CITY OF PORTLAND

Job ID: 2012-06-4345-ALTCOMM

Application Number: 2012-488 **Application Date:** 4/23/2012 12:00:00
CBL: 271-A-2 AM
Project Name: Portland Sports Center Training Facility
Address: 550 Warren Avenue

From: Marge Schmuckal
To: Barbara Barhydt
Date: 4/26/2012 12:51 PM
Subject: 550 Warren Avenue - Protland Sports Center Training Facility

SCALE: 1" = 40'	APPROVED BY:	DRAWN BY: EAB
DATE: 4/19/12		REVISION : DATE B : 5/25/12
JOB NO: C089-12	CAD FILE: DOME SITE	SHEET 1 OF

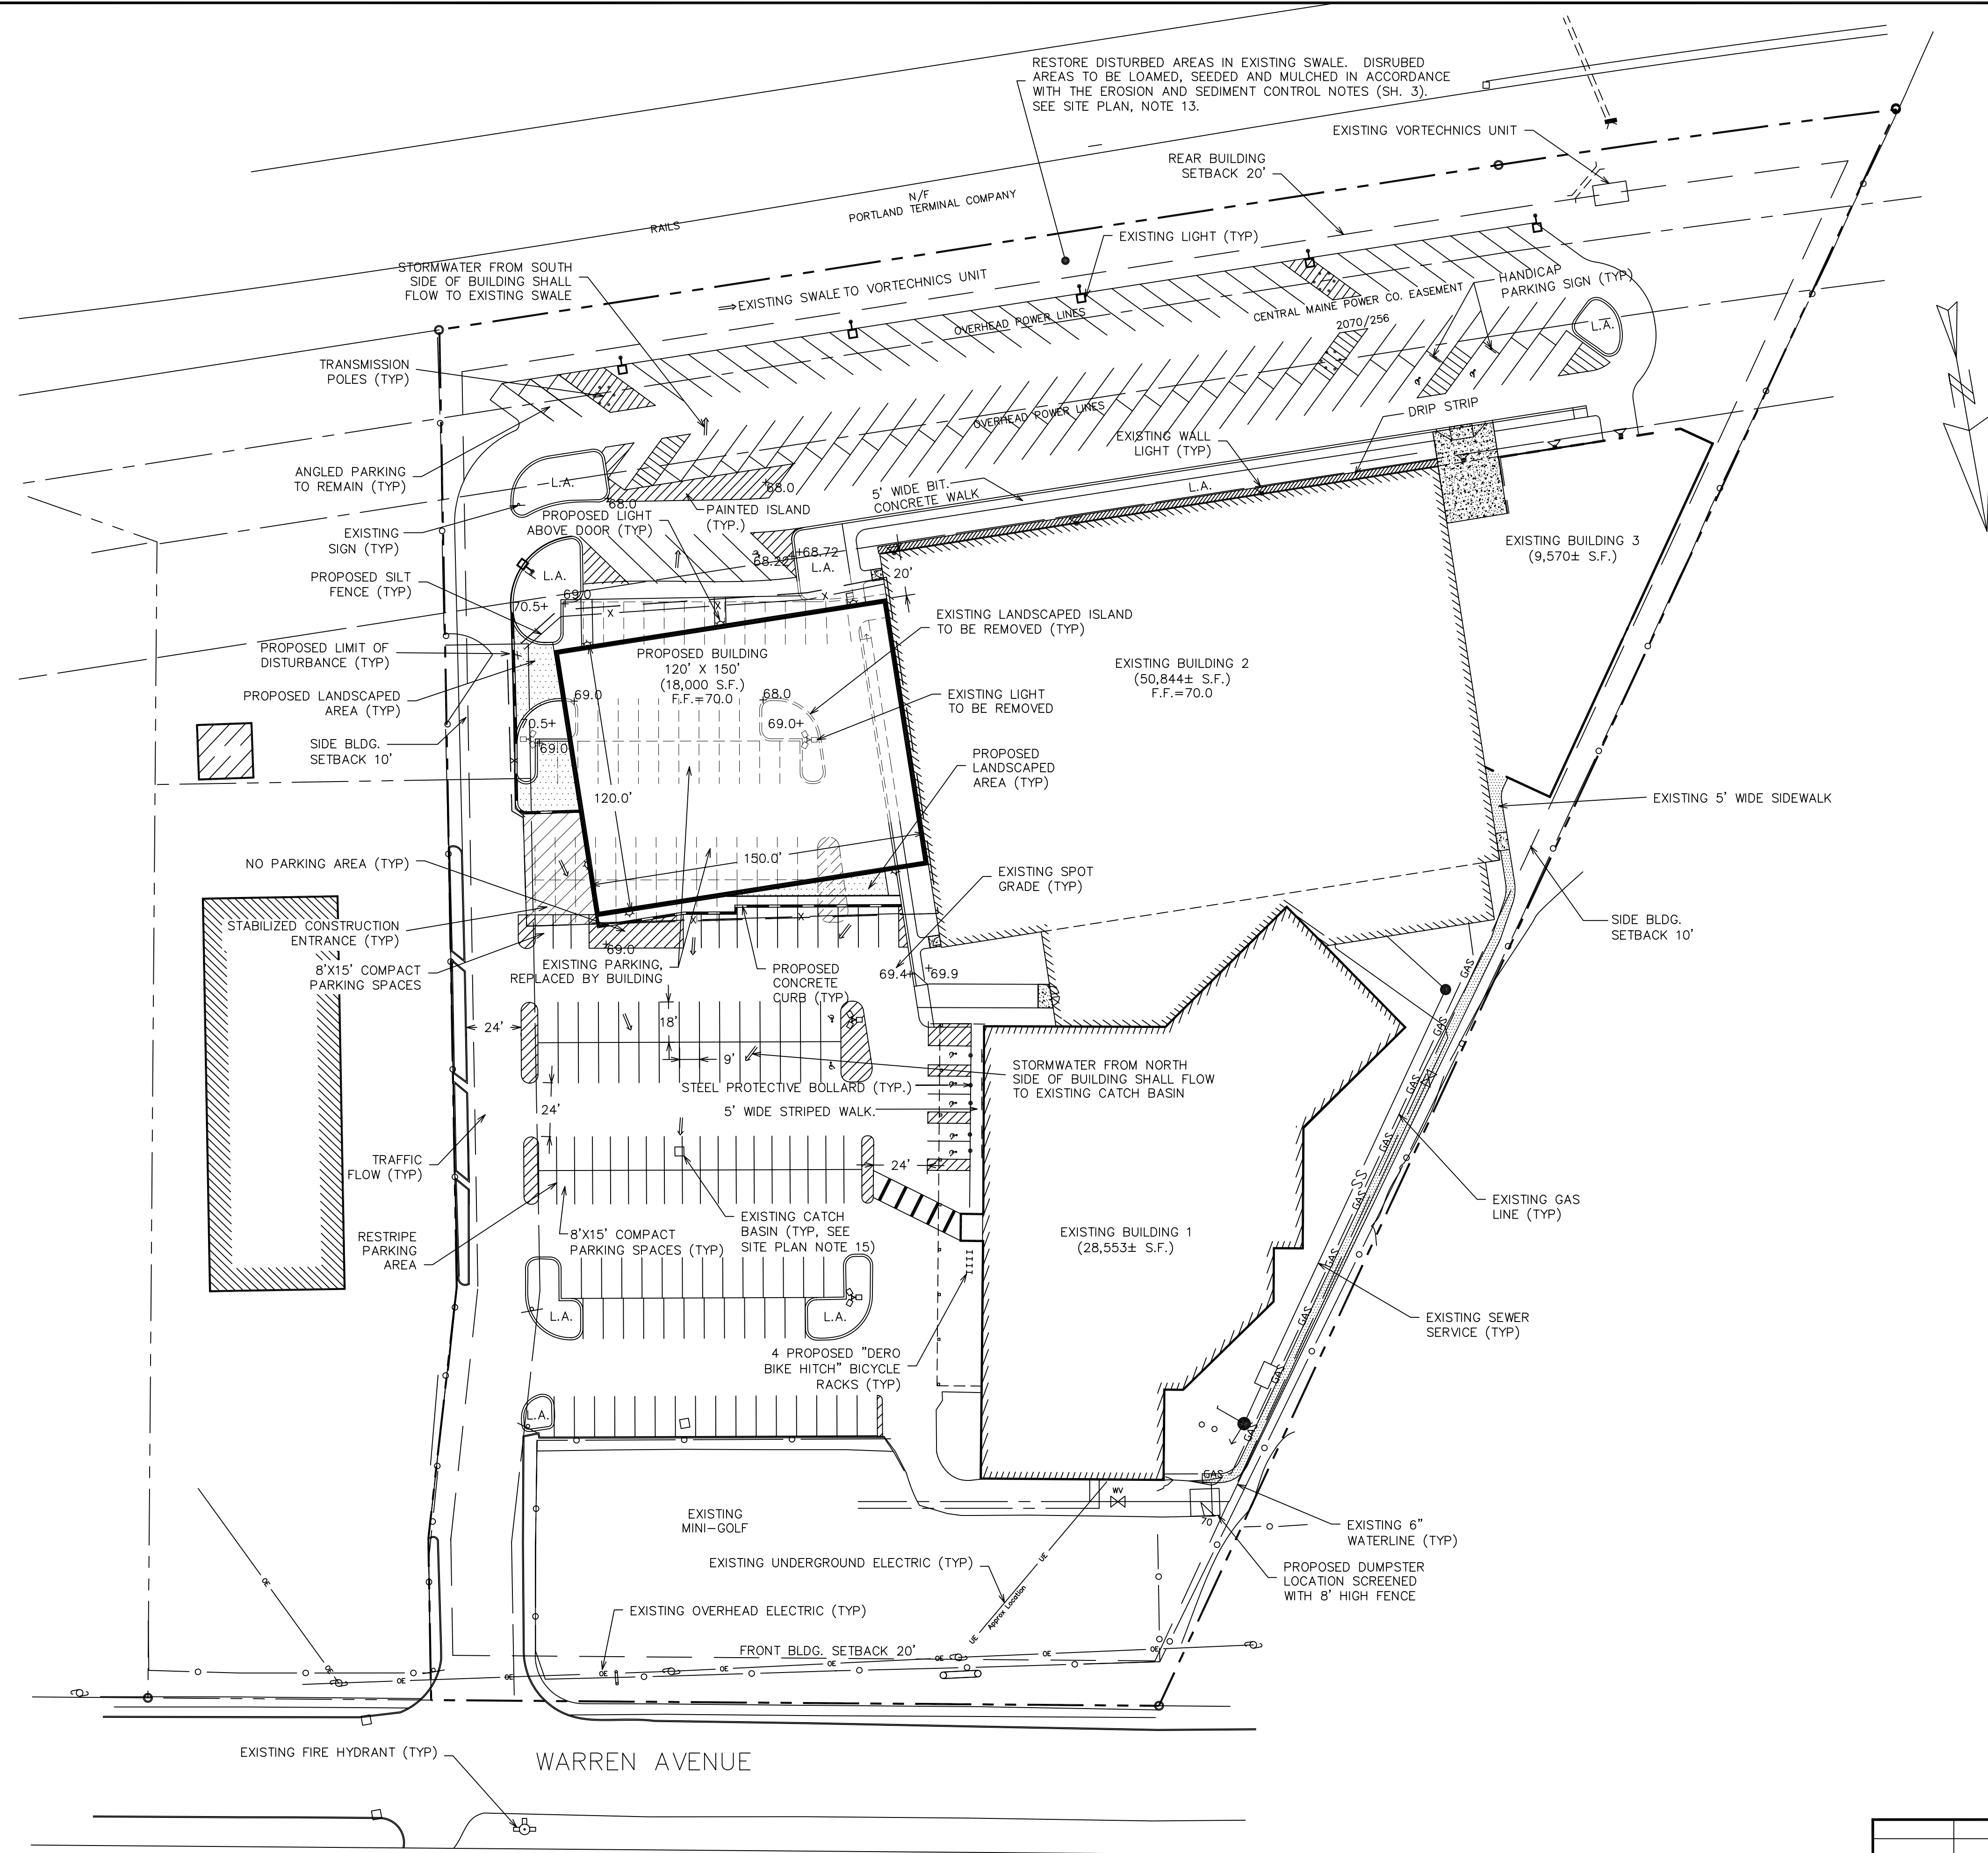
The proposal is to erect a one story addition to the existing 50,844 sq. ft. Portland Sports Center dome that was erected in 2003. the addition is to be 120' x 150' in an area of existing parking. The given site plan shows that the entire property is located in a B-4 business zone. However, I am curious about whether the applicant owns additional land as part of this property. In 2007, the City was approached by the current owners to rezone a parcel of land in the R-3 zone immediately abutting this property. So I am wondering what happened to that parcel? Is it no longer a part of this property. I would like just a little bit of explanation concerning that parcel.

All the setback requirements of the B-4 zone are being met along with the maximum impervious surface requirement of 80% (showing 75.48%). I understand the building to be one story. However, I do not recall seeing an elevation of the building in the submission. I would like to confirm the building height. I do not expect this to be an issue.

The building height on this project is 34 feet. I think 65 is the limit in the B-4 zone, so the owner should be set, but I wanted to offer you the chance to comment.
